From: Planning
Subject: FW: Application 3/2026/0156 - Attn Anna Robinson
Attachments: S26033010280.pdf

From: Richard White <
Sent: 30 March 2026 10:25
To: Planning <planning@ribblevalley.gov.uk>
Subject: Application 3/2026/0156 - Attn Anna Robinson

I've noticed Highways have responded to my application 3/2026/0156 and wanted to respond to their points raised in their conditions:

project	Highfield	project number	26.11	drawing number	PL.03
title	Construction Management Plan				
scale	1 to 200 @ A3	date	March 2026	status	planning
				revision	A

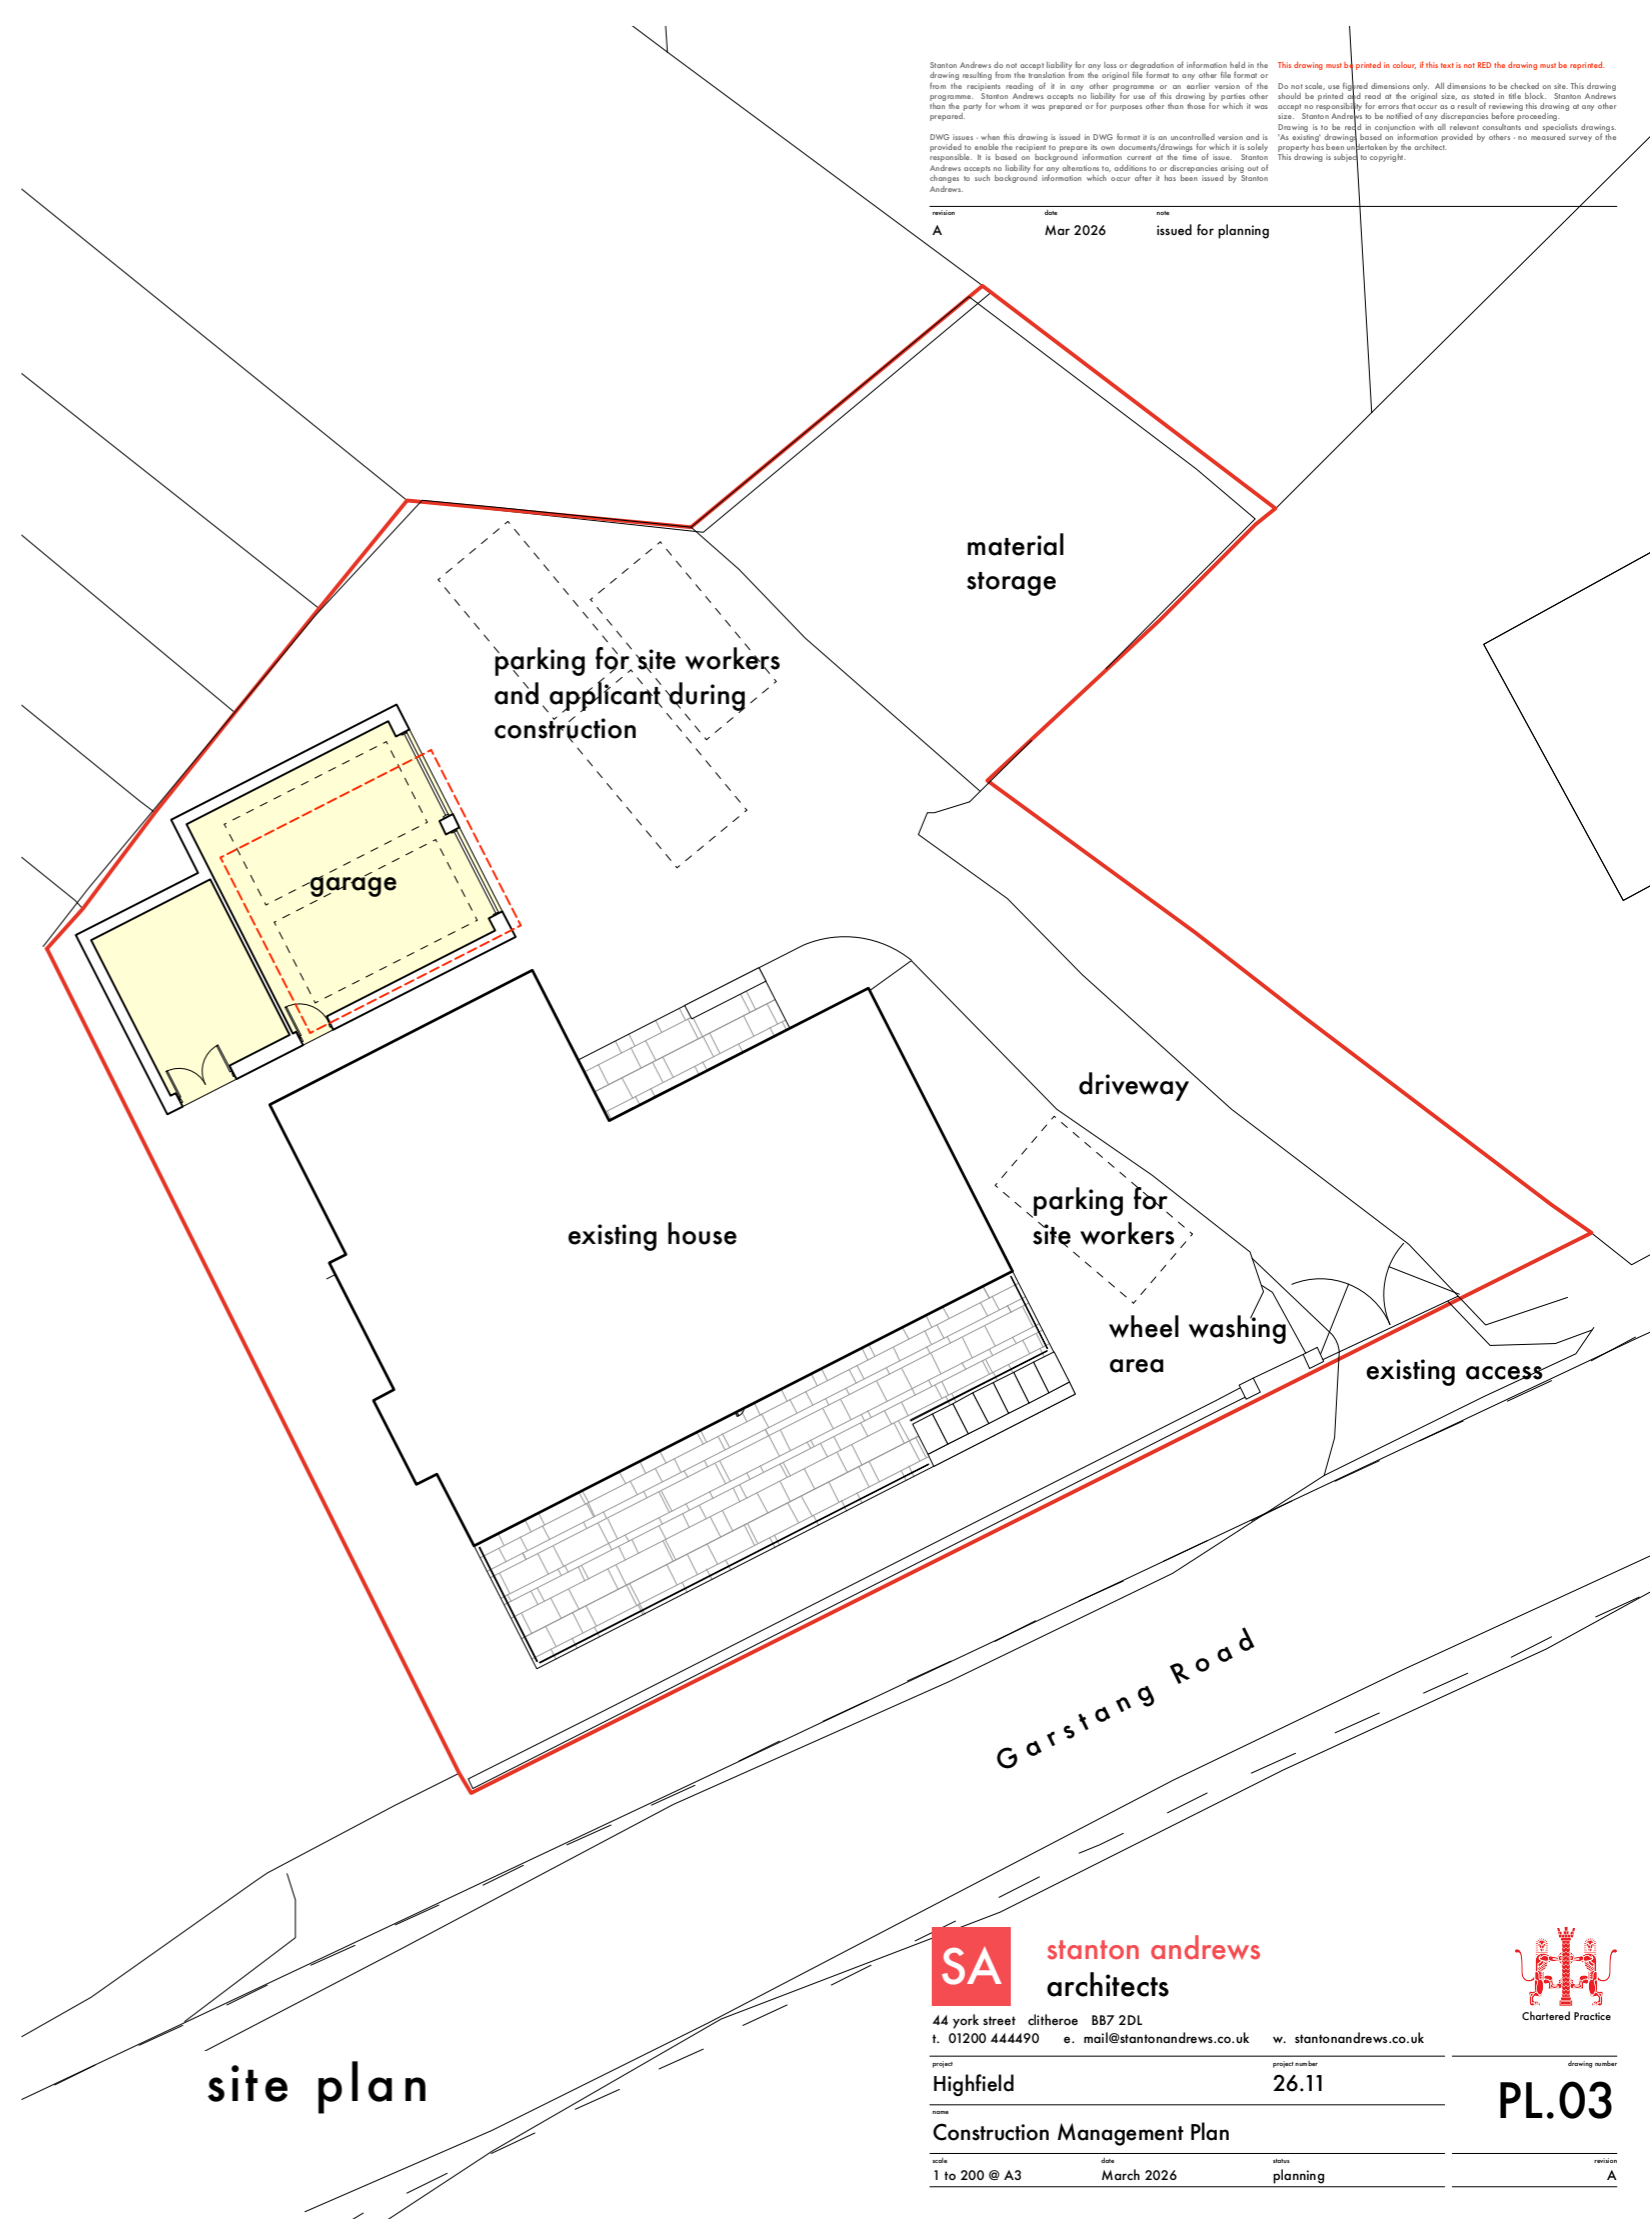
- 3. Prior to work starting on site a construction management plan is produced for approval. This should highlight how deliveries during construction will be managed and where workers on the site will park during construction. Reason: to minimise the impact of construction on existing residents and pedestrians in the vicinity of the site.*

Response – All deliveries will be made onto the driveway, all workers will be able to park further up the driveway and at the concreted yard area at the top of the drive in front of the garage. Please see attached drawing to indicate how the site will be run to ensure no disruption to the highway.
